Final Report - Corrections Required **Application No. LUPL-25-0008**

Document Filename : 241010_BLR Village C Land Use Plan.pdf

BANNING LEWIS RANCH - VILLAGE C
LAND USE PLAN
COLORADO SPRINGS, CO
LAND USE PLAN

Please use this on the coversheet as well.

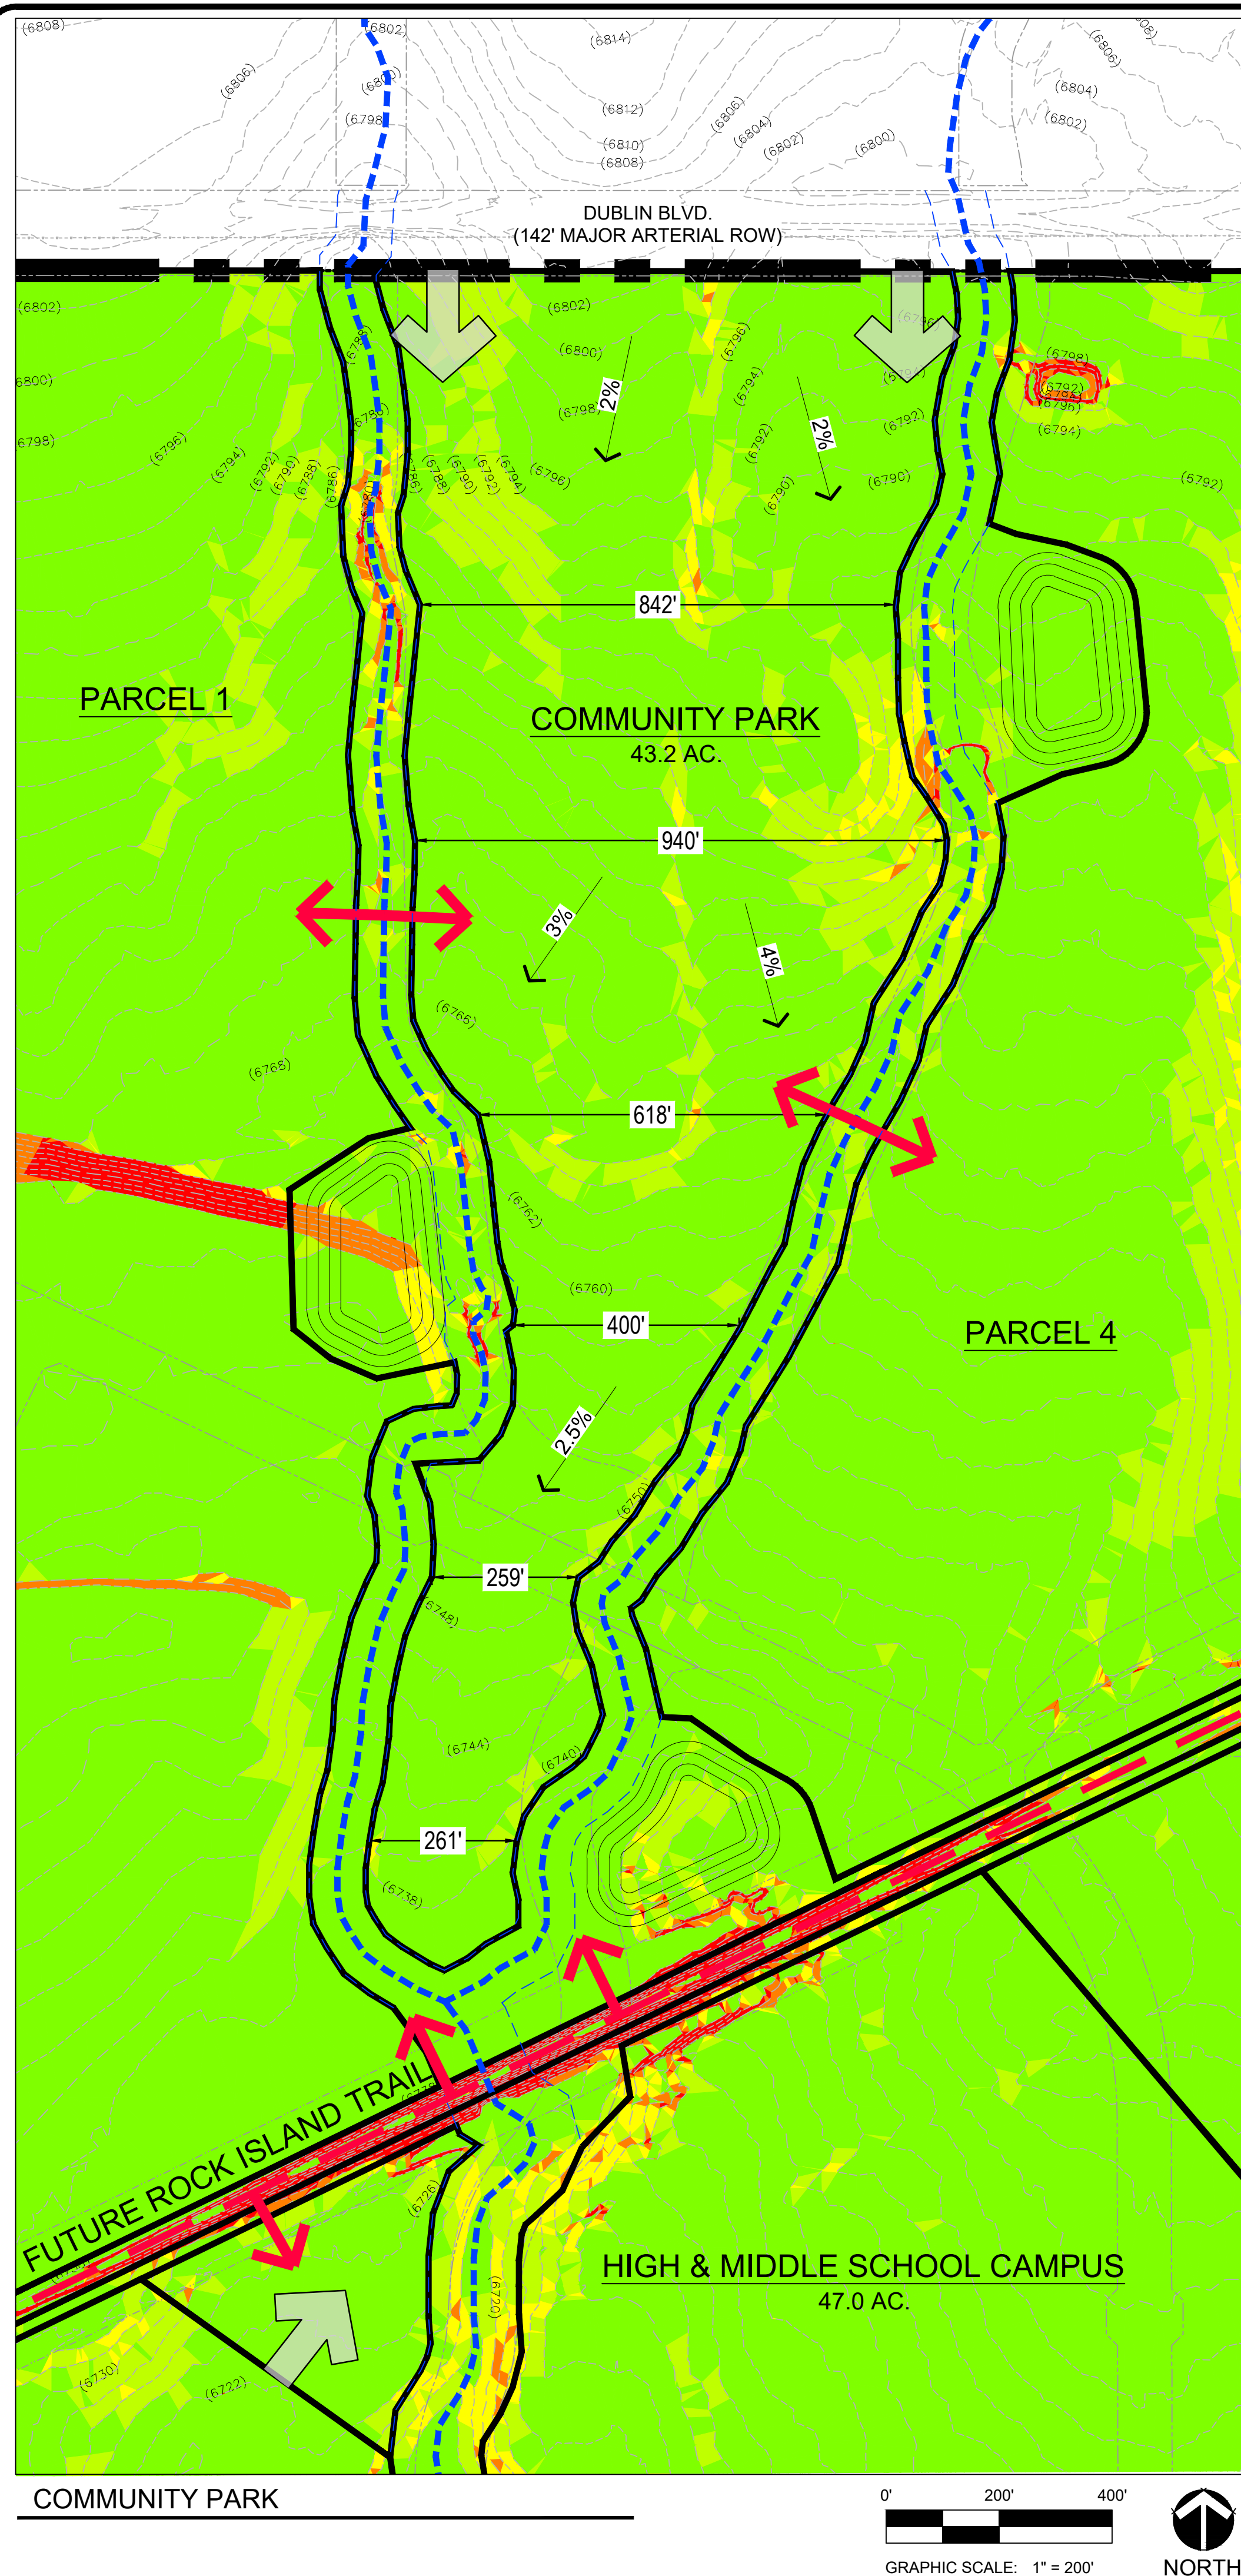
53	2	Tamara Baxter : Planning	Please use this on the coversheet as well.
54	2	Tamara Baxter : Planning	What does this residential encompass?
30	3	Caroline Miller : Planning	This graphic doesn't match the LUP Bubbles shown on page 2, park is not next to Public Safety.
